Subject: RE: WSCC Highway Comments - BE/121/2- - Revised Construction Management Plan for Saltbox

From: Ian Gledhill [REDACTED]
Sent: 03 November 2020 16:07
To: Michael Eastham <Michael.Eastham@arun.gov.uk>
Cc: Planning.Responses <Planning.Responses@arun.gov.uk>
Subject: WSCC Highway Comments - BE/121/2- - Revised Construction Management Plan for Saltbox

Logistics and Traffic Management Plans

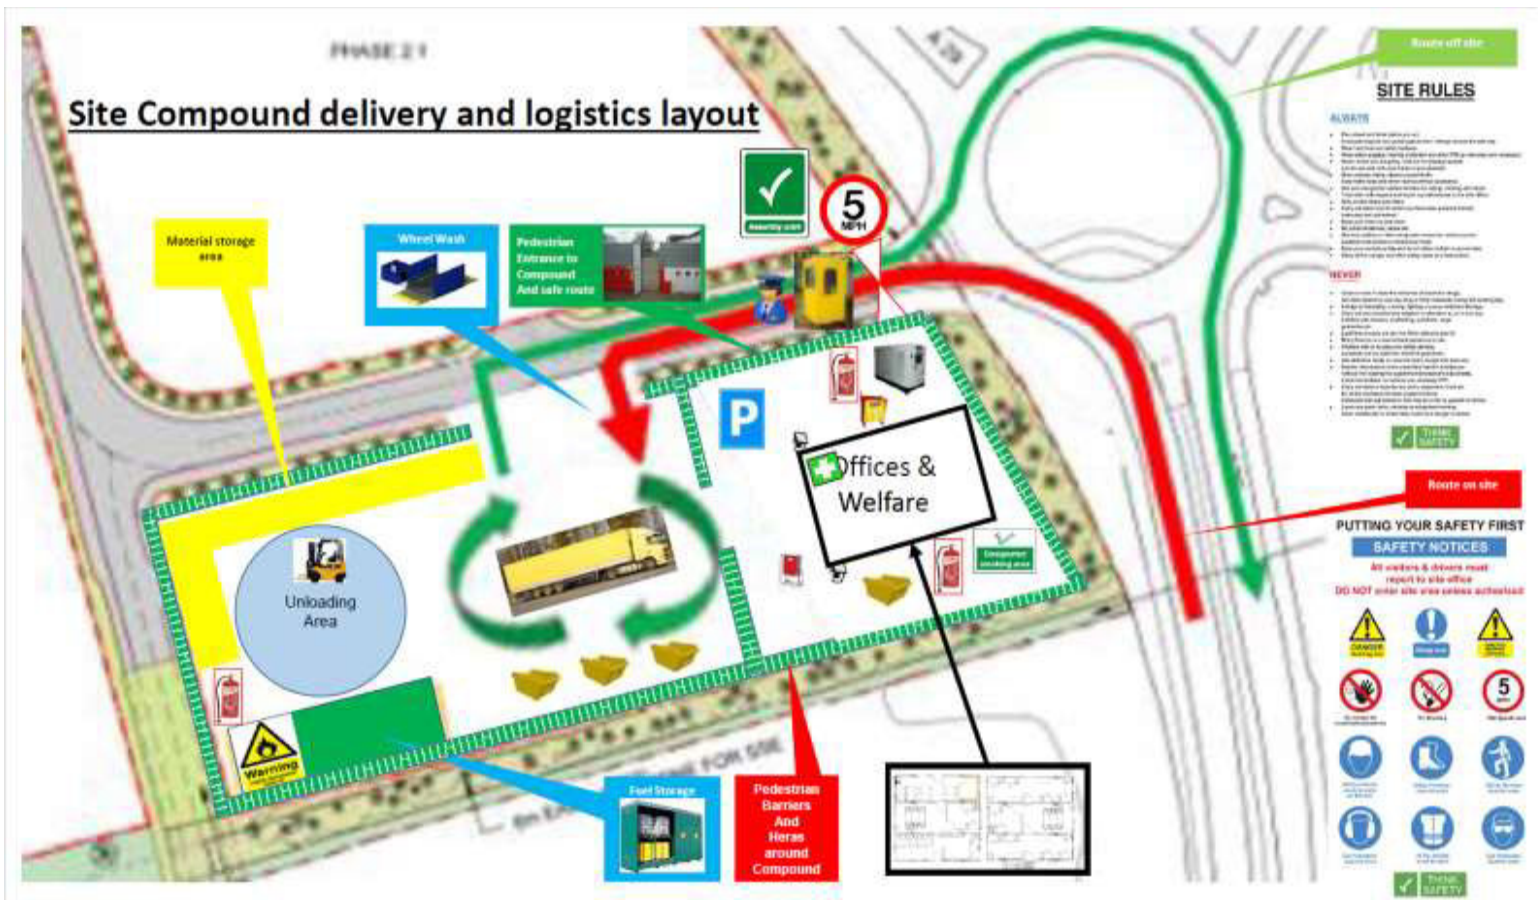
Access is now available from the additional arm off the Felpham Relief Road Roundabout rather than the existing field access to the north, so this has simplified highway matters. The only comment I'd have is in respects of the routing as shown on the Logistics and Traffic Management Plan in appendix 3. This plan shows all deliveries arriving and departing to the south. This isn't an issue in itself, but it is prescribing unnecessarily that all deliveries are required to arrive and depart to the south. There's no reason why traffic couldn't use the A29 to the north or the A259 to the east. I'd have no issue with this plan being amended so as to allow deliveries to arrive via any of the A roads in the vicinity of the site.
